OXFORDSHIRE COUNTY COUNCIL'S RESPONSE TO CONSULTATION ON THE FOLLOWING DEVELOPMENT PROPOSAL

Application no: 21/04202/F

Proposal: Redevelopment for 80 retirement living apartments including communal facilities, access, car parking and landscaping.

Location: Former Buzz Bingo, Bolton Road, Banbury

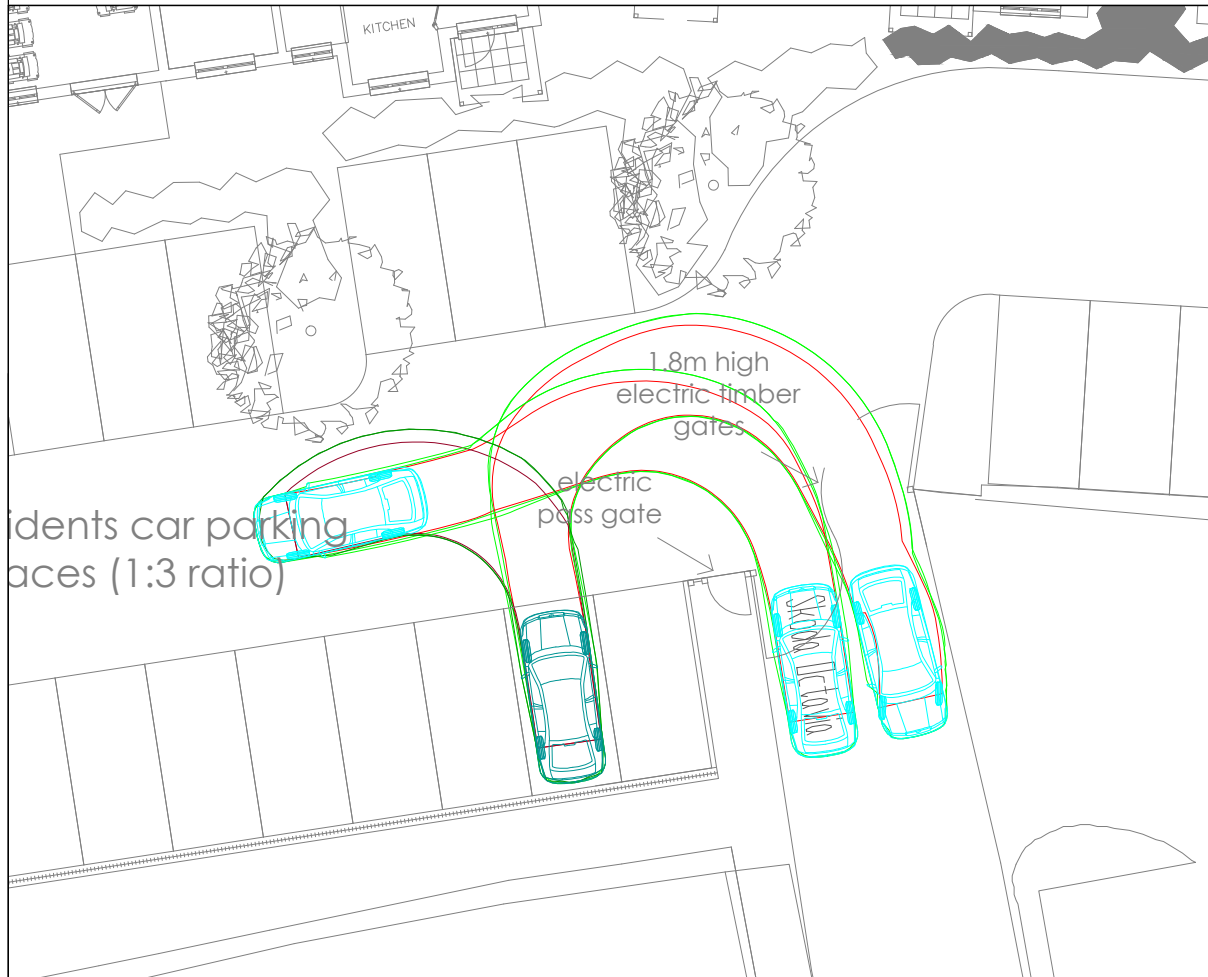
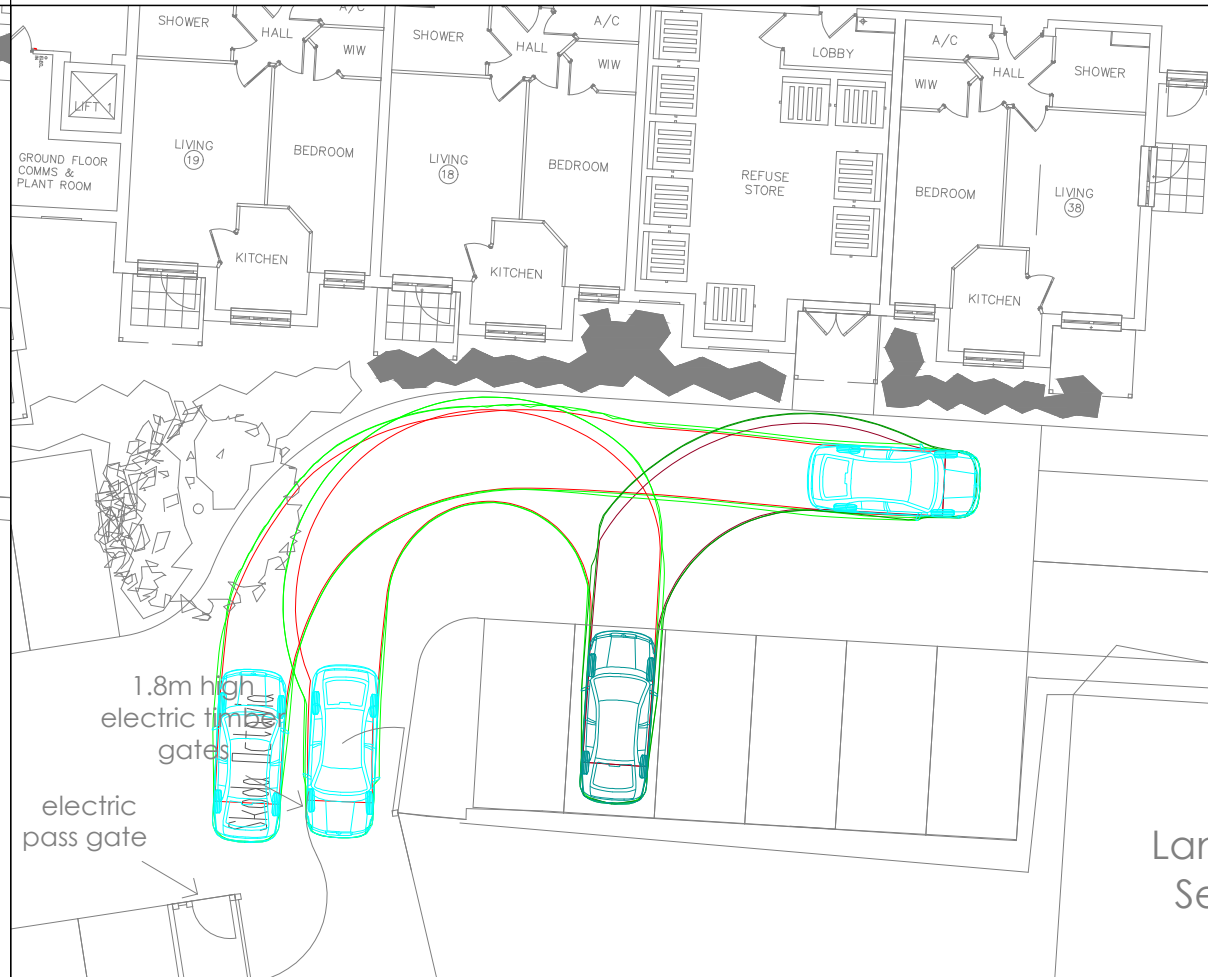
OCC's primary concern relates to the on-site manoeuvring of refuse vehicles in relation to the submitted revised parking layout plan (drawing no.536.0037.003 Rev D)

The extract of the drawing below shows that manoeuvring can be done in theory albeit that the vehicle is effectively touching some of the boundaries and would likely be very difficult in reality. This constraint could be overcome by moving the end of the footway (and access gate) back slightly (sketched below). This would have the added benefit of allowing the adjacent 1.8m fence to be lowered or removed to provide visibility of pedestrians entering the car park area. This would be one example, there other minor amendment options that could be made to accommodate it
